December 1, 2006

**Re: Status of Improvement Permit Application #06-5-16171 – Lt 32 Laurel Valley  
#06-5-16174 – Lt 66 Laurel Valley**

Joe West, R. S.  
Environmental Health Specialist  
Harnett County Department of Public Health

P+S Home Builders LLC  
Lot # 66 LAUREL VALLEY

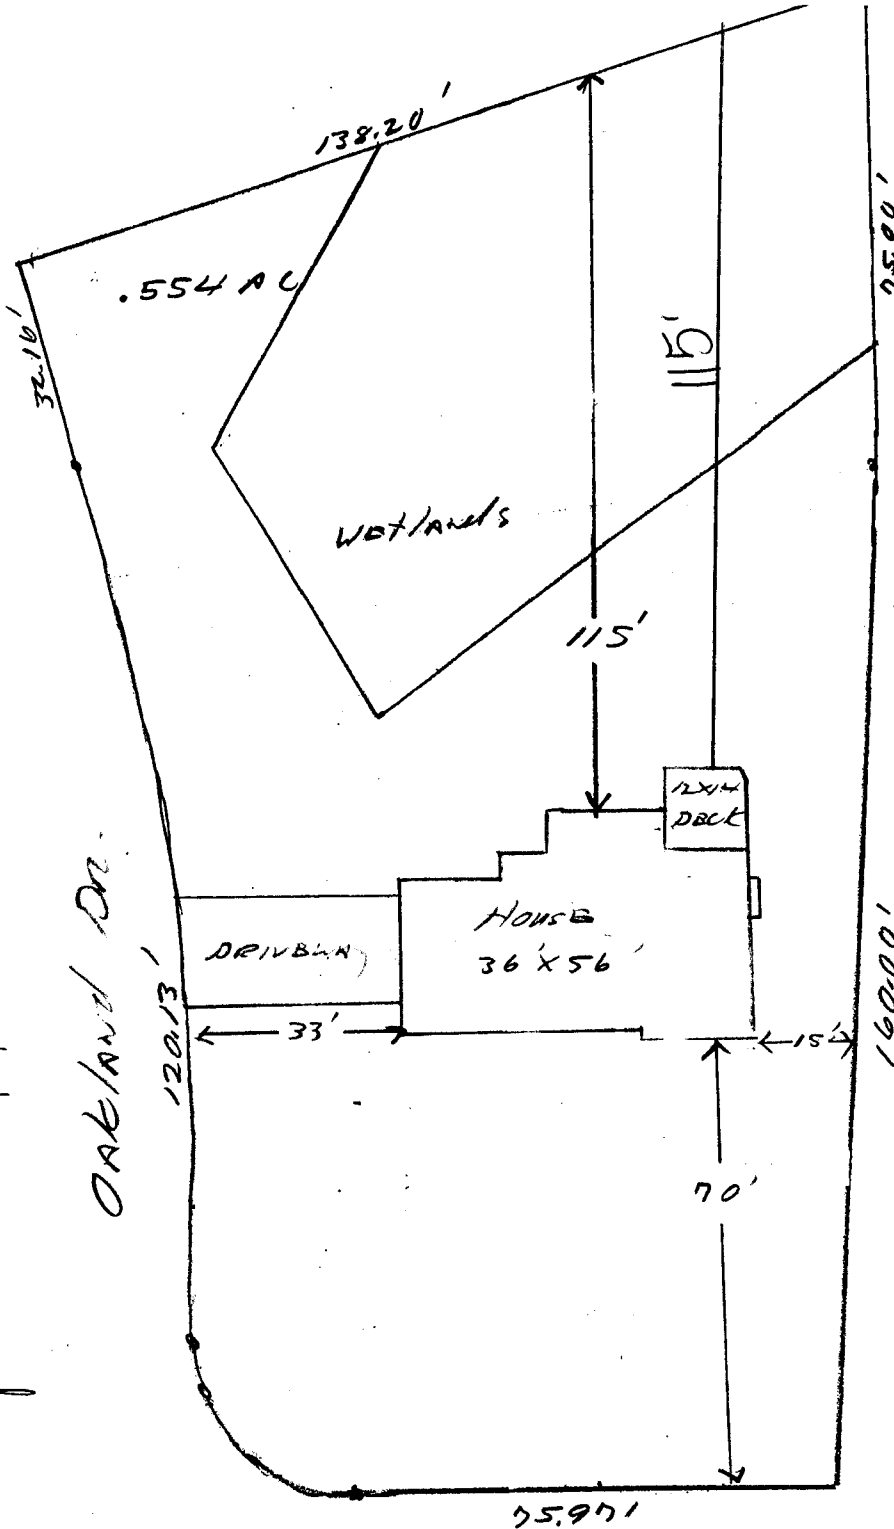
- 1. Property lines/corners not marked or labeled
- 2. House corners not marked or labeled
- 3. Directions not clear to property
- 4. Property needs brush or vegetation removed
- 5. Backhoe pits required
- 6. Other - **Make changes to house location as shown on the attached sheets. Make needed revisions at Central Permitting.**

NOTE  
Drive must  
enter home  
from Oakland Drive
